From: Darren Schofield [REDACTED]
Sent: 27 February 2018 10:39
To: Michael Eastham
Subject: RE: Courtwick Littlehampton - variation of conditions 4 & 24 - Ref LU/408/17/PL

Drawing Number				Rev.
4485/314				E

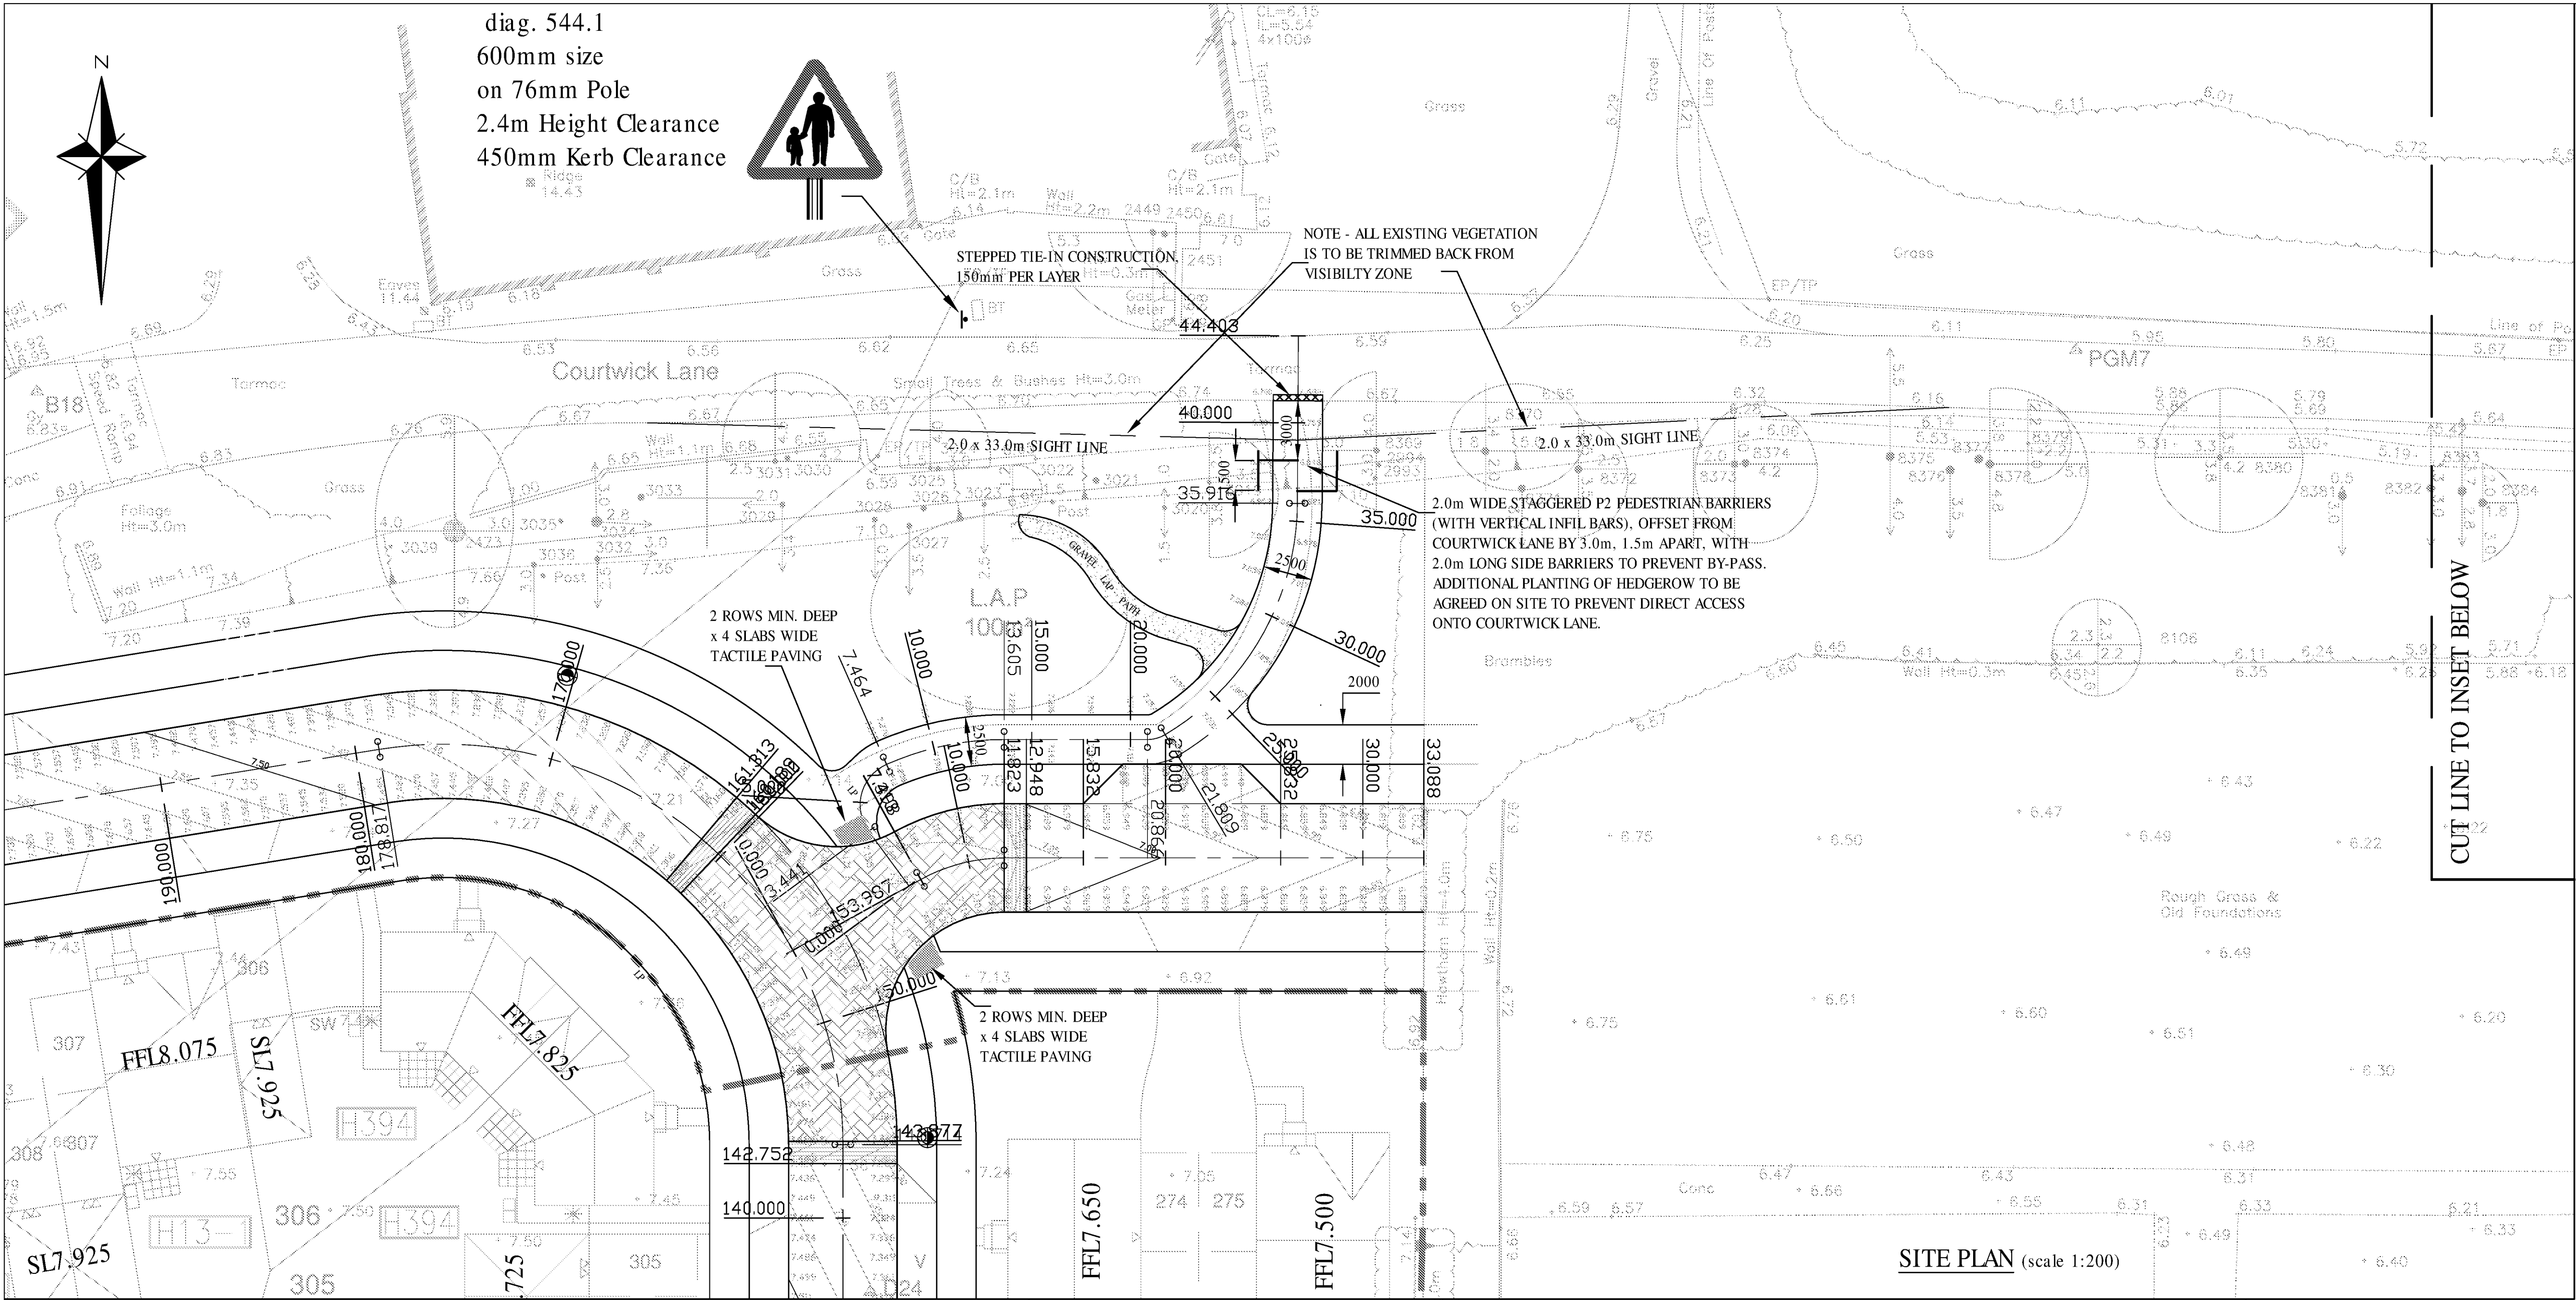
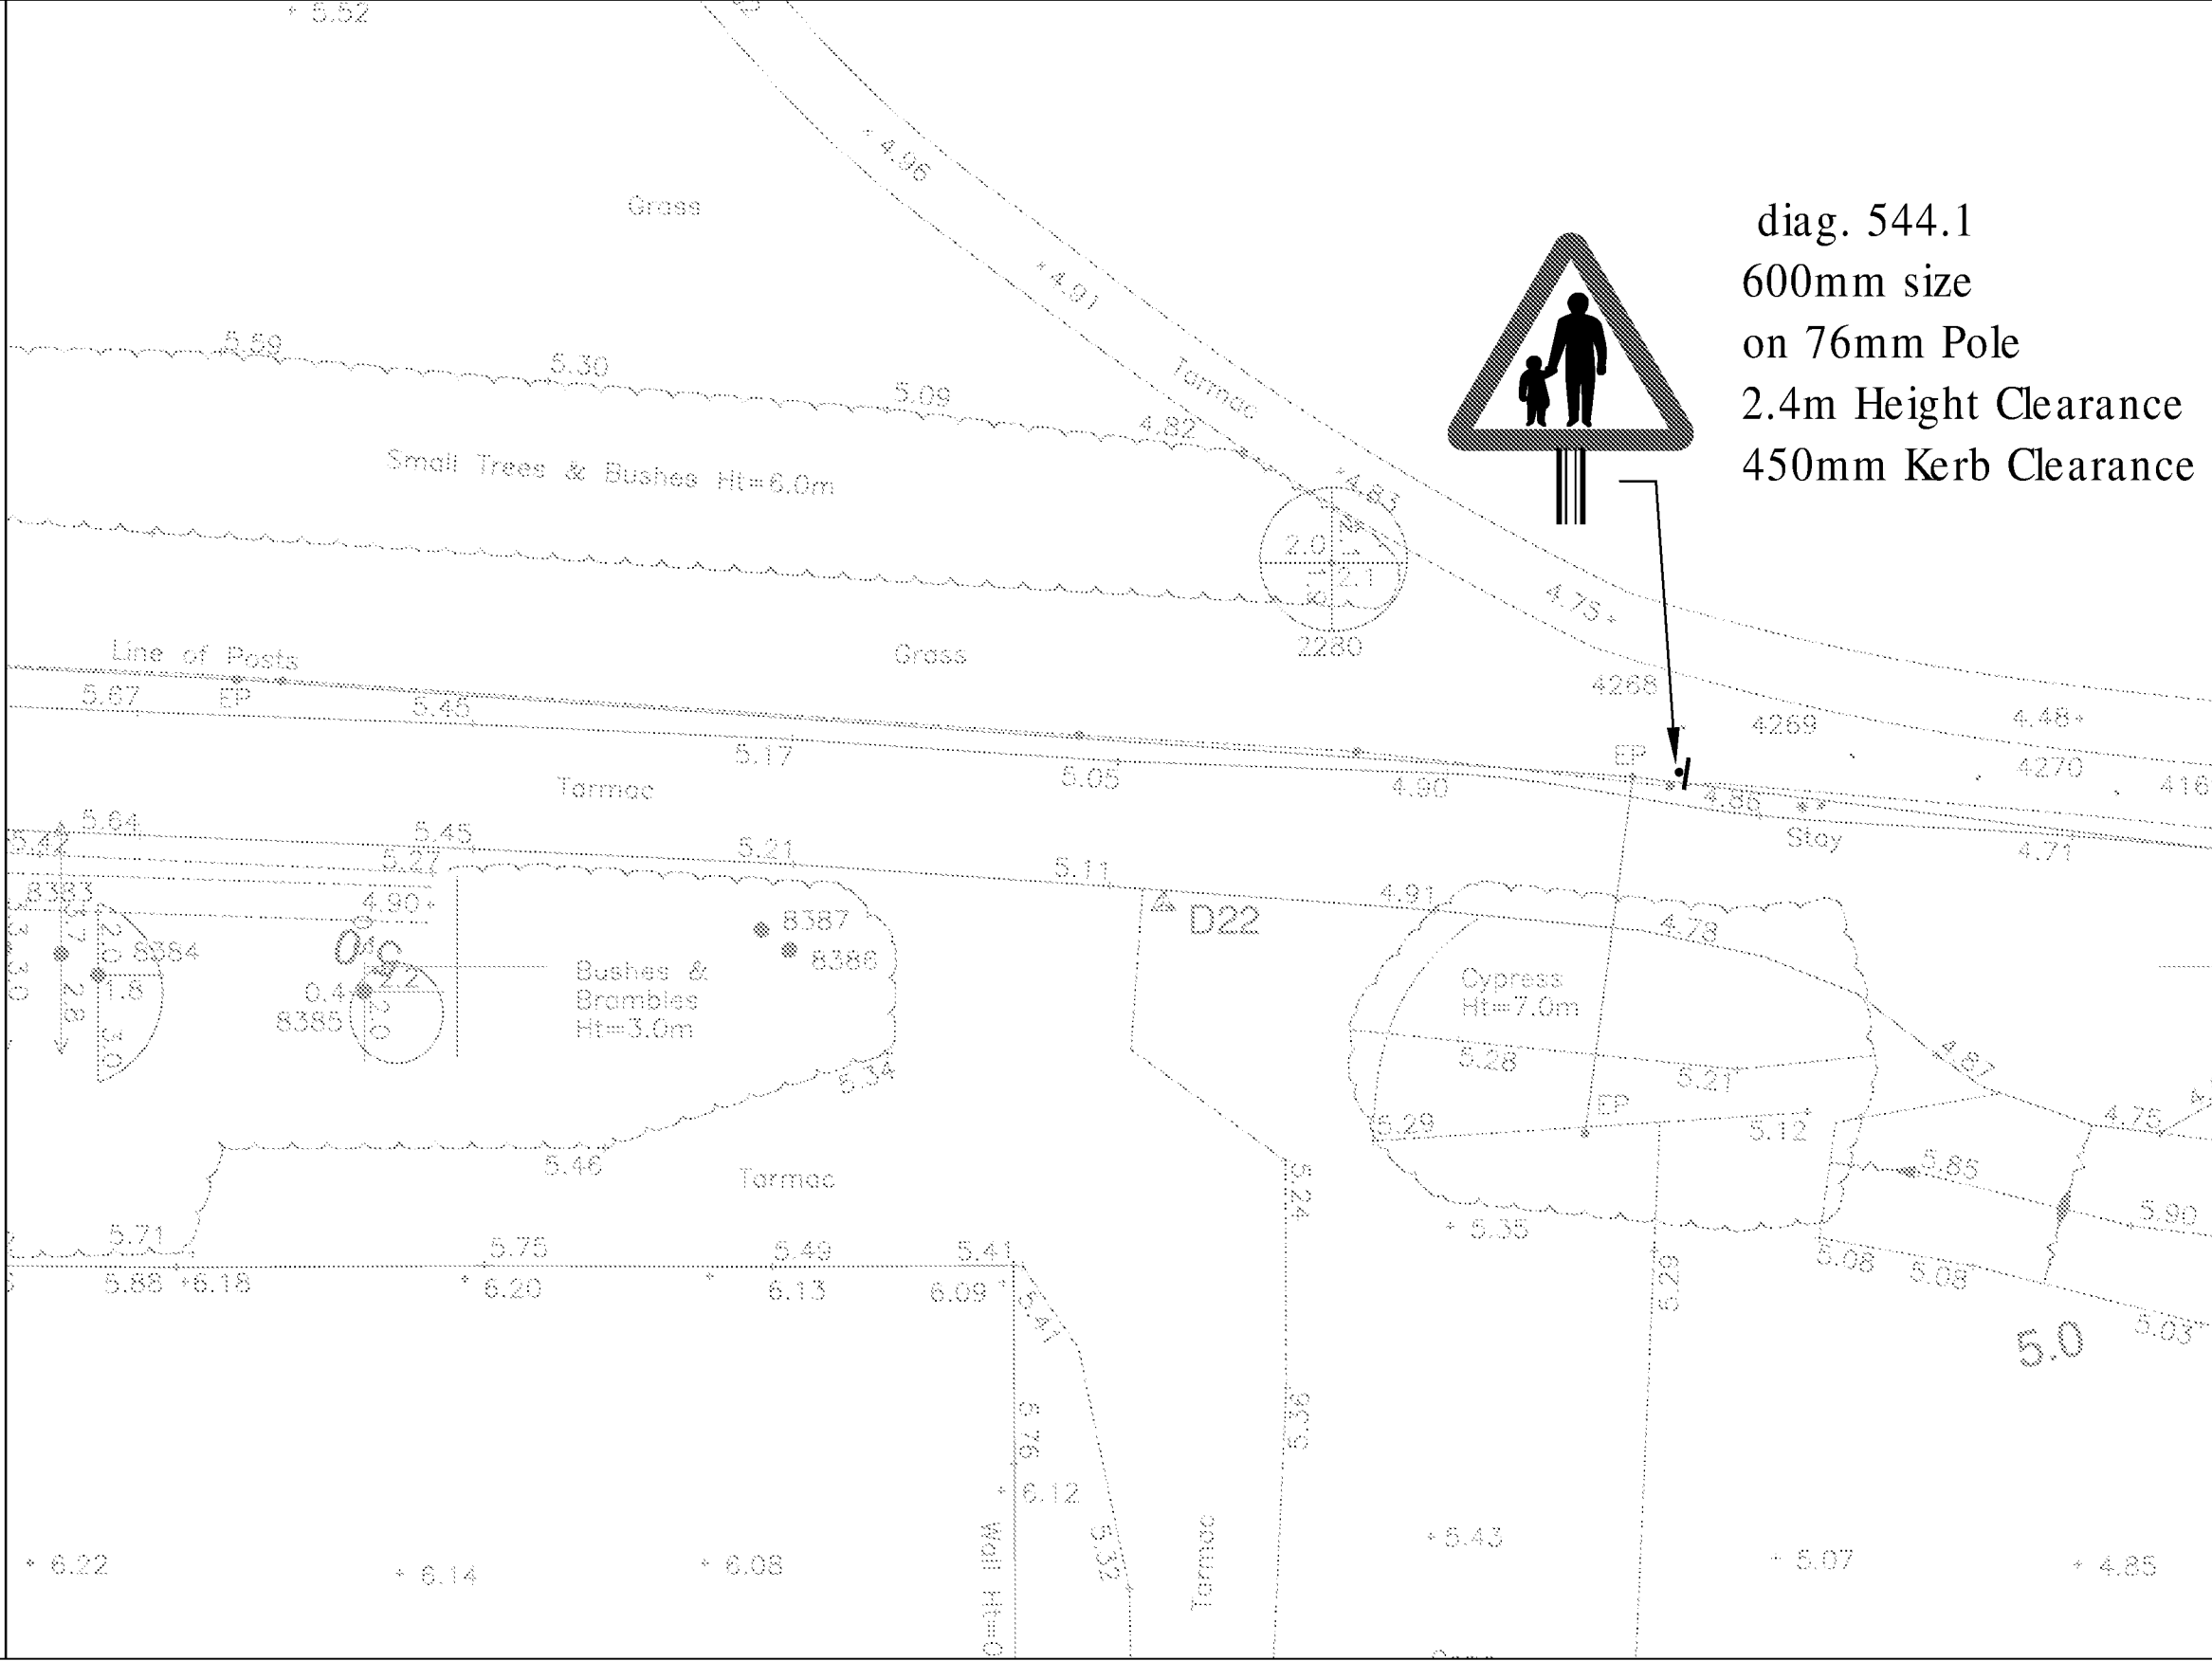
One further point that I meant to include on the email below. Please would you also ask Bellway to demonstrate on a plan that those with pushchairs and mobility scooters can negotiate the barriers. Also with the revised sight line, the barriers will need setting-back to accommodate the greater 'x' distance.

- 1. Pedestrian visibility** – This needs to be shown from a 2.0m 'x' distance - *not* 1.0m as shown. This was raised previously and discussed with Darren when I met him on site. The plan does, therefore, need to be amended.
- 2. Advance warning signage of pedestrians** – The Stage 1-2 Road Safety Audit - February 2018, para. 2.1.1 - recommends that a sign be provided on the approach to the pedestrian access warning drivers of the presence of pedestrians. WSCC recommends that a further sign be placed on the opposite approach for drivers travelling eastbound. Again, plan should be amended to show this.

I attach an updated plan picking up on Tim's comments, along with a barrier chicane standard detail.
